Re: 225 Industrial Way, Portland, Maine

HWE P/N 10-039

At your request, I inspected the visible structure of the three mezzanines as built in your building at 225 Industrial Way, Portland, Maine. John provided access to the space.

STRUCTURAL

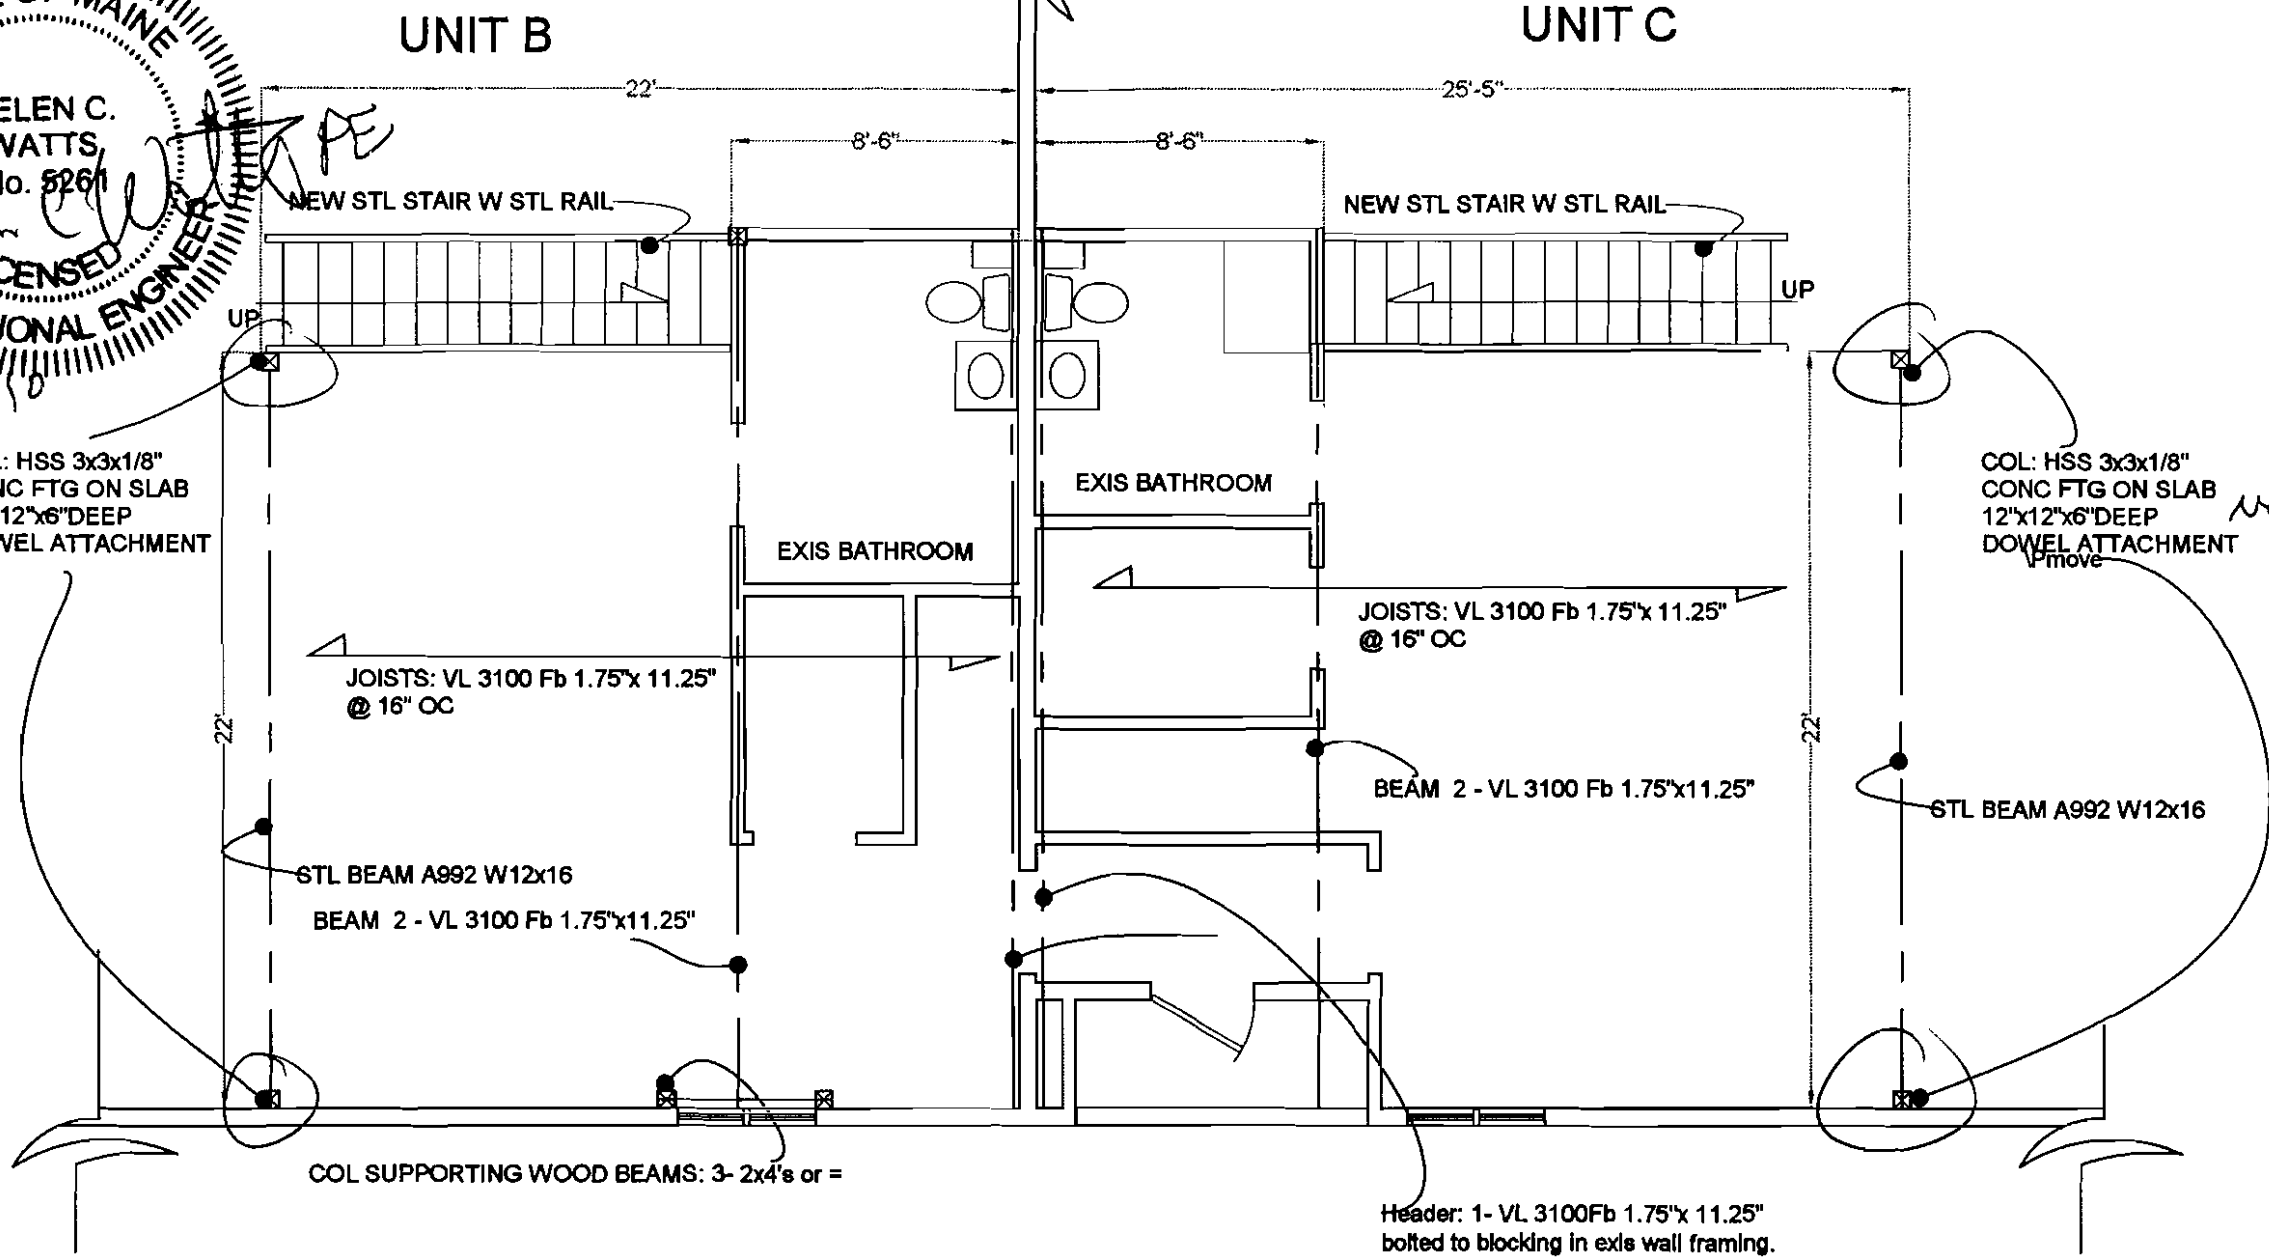
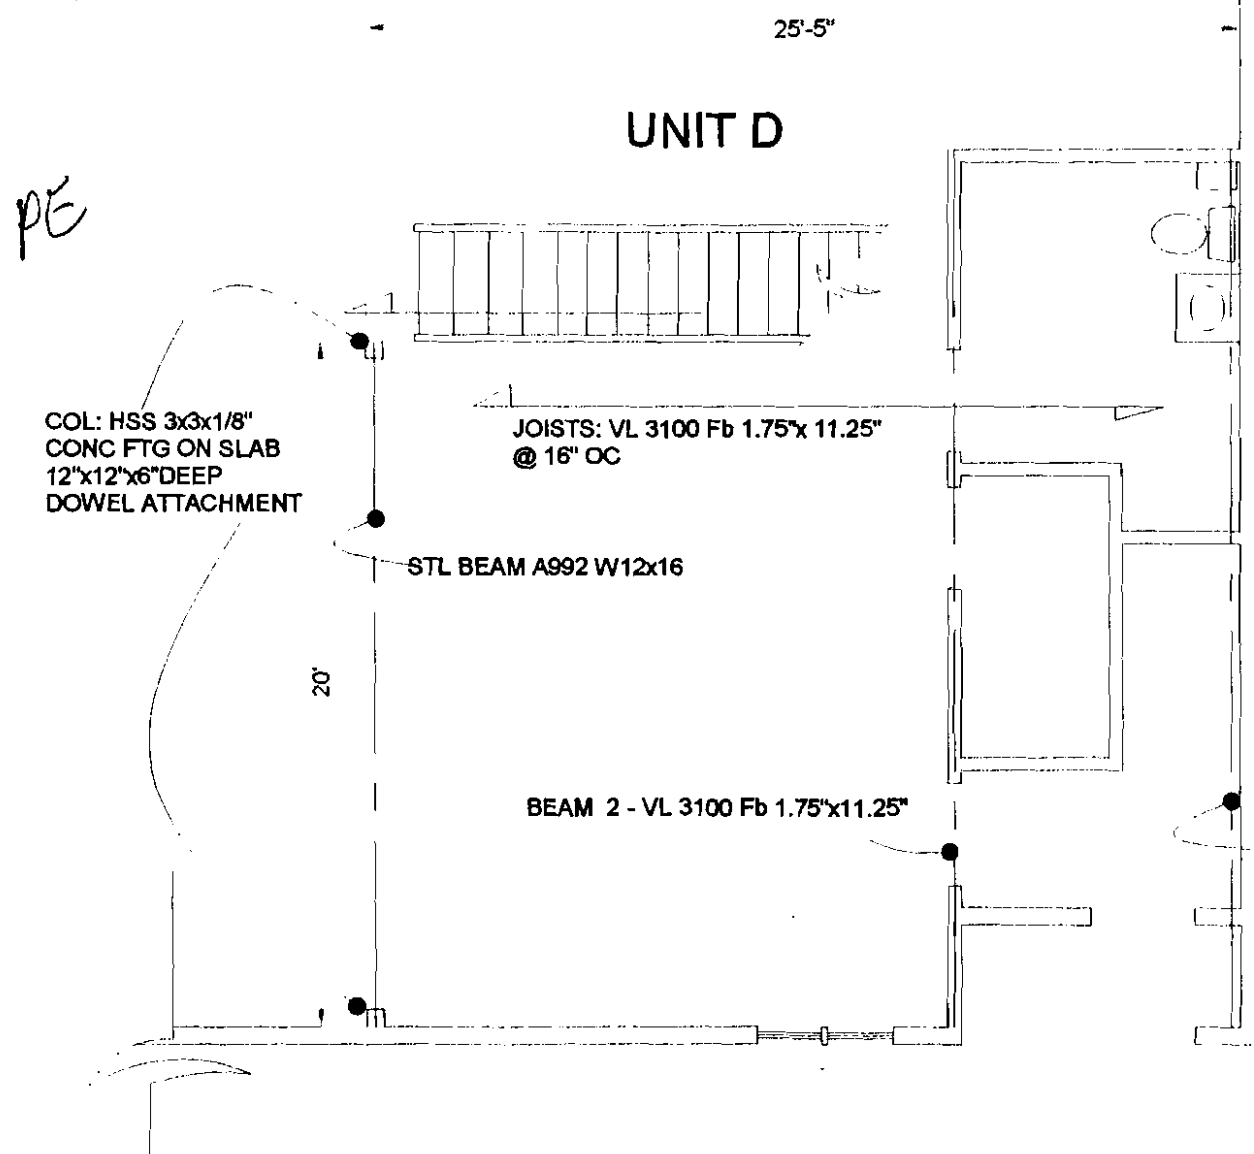
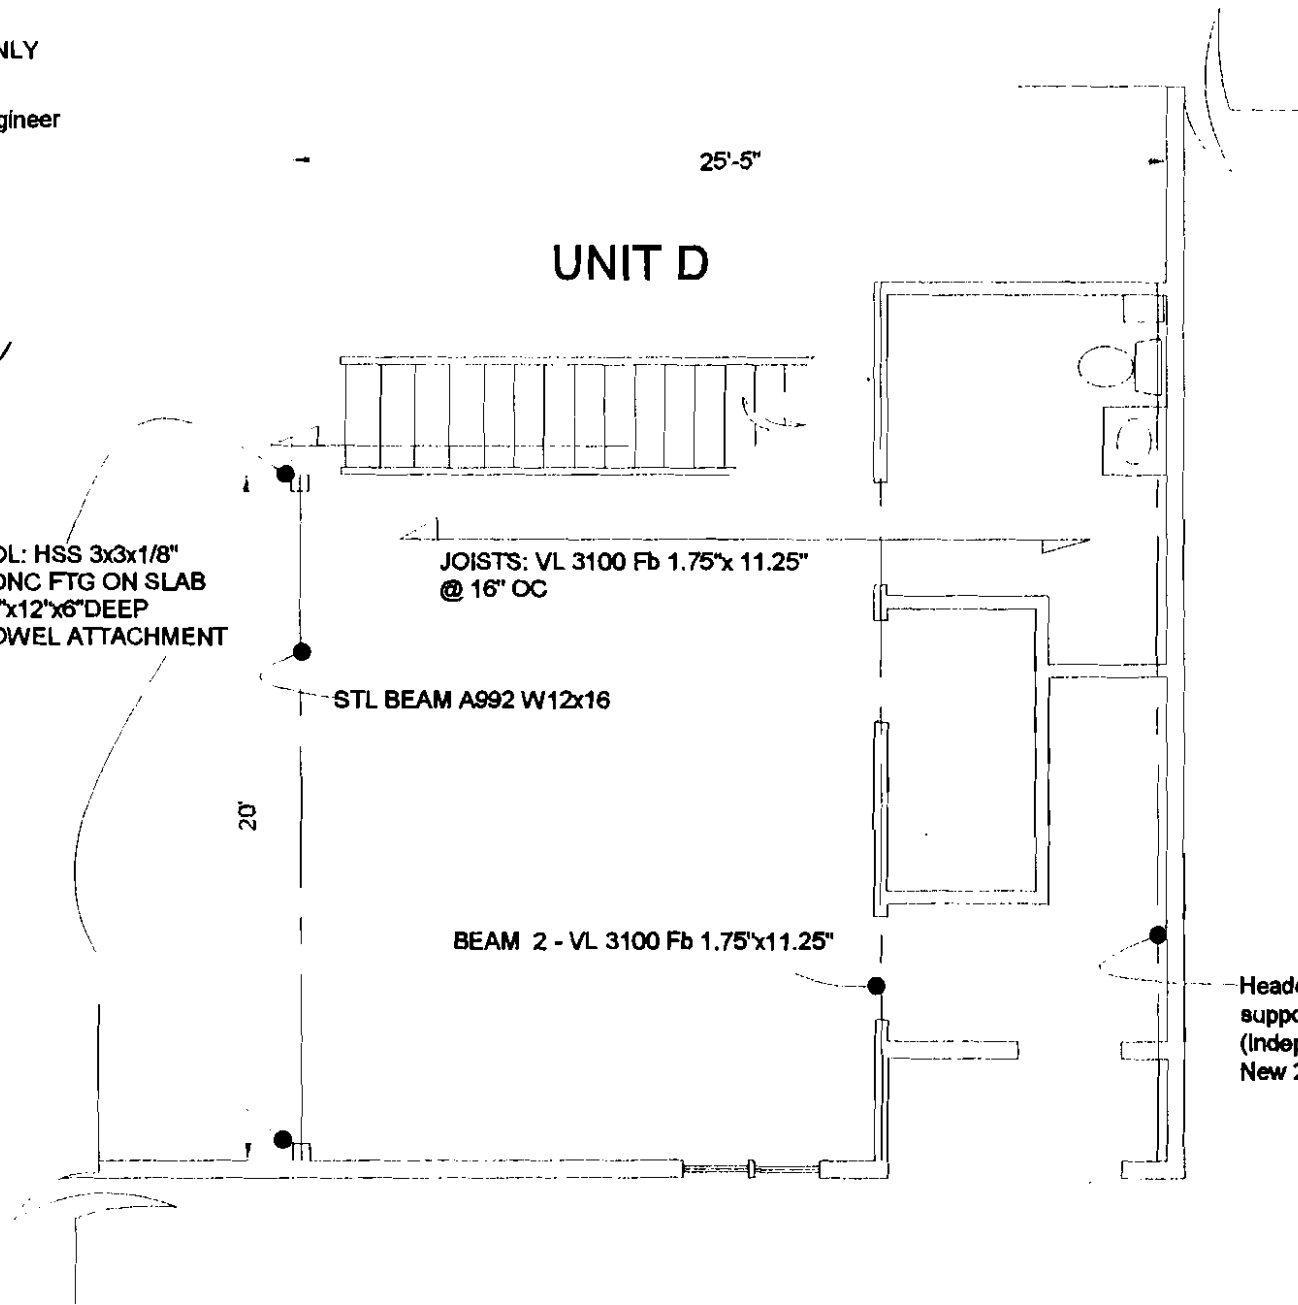
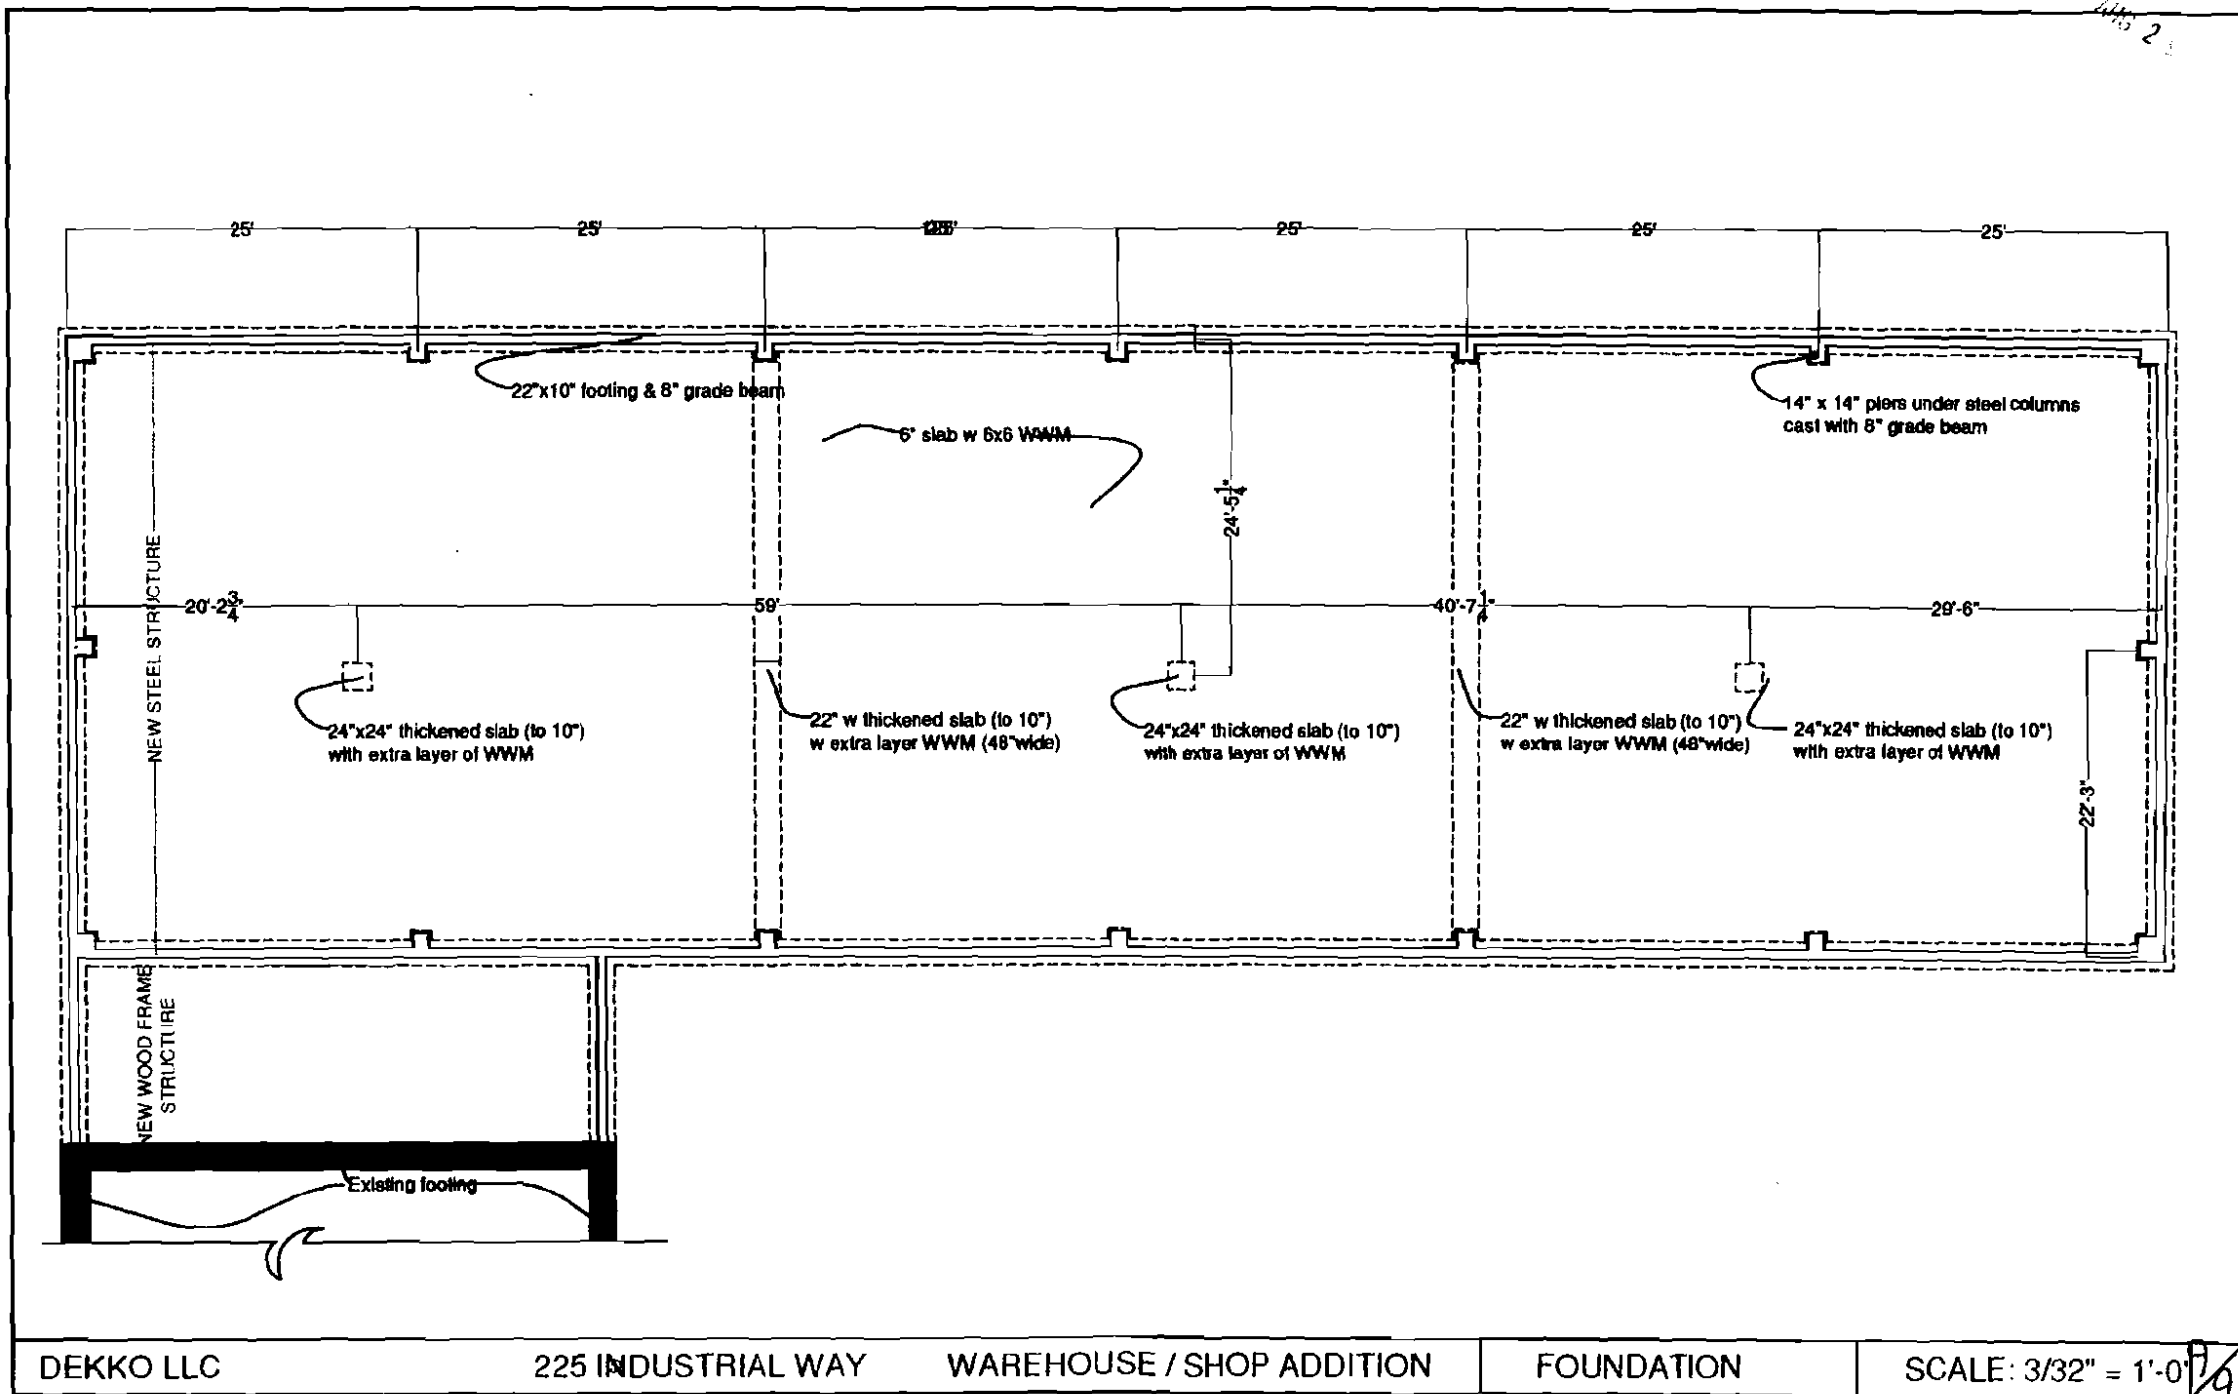
1. At the metal-stud bearing wall between the three sections of the building: Kamco studs are assumed to be equal to Dietrich 20 gauge 6" metal studs. Where framing is supported off the metal stud walls, the header is to be SPF#2 2x12 or better (*a 12" LVL was used*), attached to the studs with Dietrich S689 EasyClip™ S-Series™ Clip Angles or equal, see: (<http://www.dietrichindustries.com/products/>, p. 100-101, Floor Framing Connections), 9 screws to header, #10 metal screws, fill all holes to the metal stud.

2. Hanger for joists to header: Assume 630(12/16) = 473 plf header or 630#/stud @ 16" OC. At the steel-stud-framed walls between the three sections of the building, install Simpson LBV1.56/11.25 Hanger, or equal, full nailing, header to LVL joist. *Double joist hangers were used as needed.*

3. At steel beams: bolt 2x4 plate to top of steel beams to fasten a rim joist and LVL joists. *The joists are run over the steel beam so do not require a hanger.*

4. Columns: bolt 6x4x1/4" x 4" to bottom flange, 2 - 3/8" bolts, 4 - wood screws into column. One angle per column. *The bolting detail has the bolt welded to the steel flange to make a flat connection from the steel tube column to the steel beam. This is an adequate attachment.*

5. Columns at slab, bolt 6x4x1/4" x 4" angle to floor, 1 - 1/2" expansion bolt, 4 - wood screws to column. *The columns are placed on a cast-in-place base on the slab; the base is anchored to the slab with 4 dowels and the column is anchored to the base with a welded plate and four bolts. This is an adequate support and attachment. There is one steel column in Mezzanine D which is bolted to the concrete frost wall. This is an adequate support and attachment.*

6. *The outside edge of the mezzanine at the exterior wall is supported by a 2x4 which is attached to the exterior siding panels with a metal screw. This is lightly loaded, and adequate support is provided.*
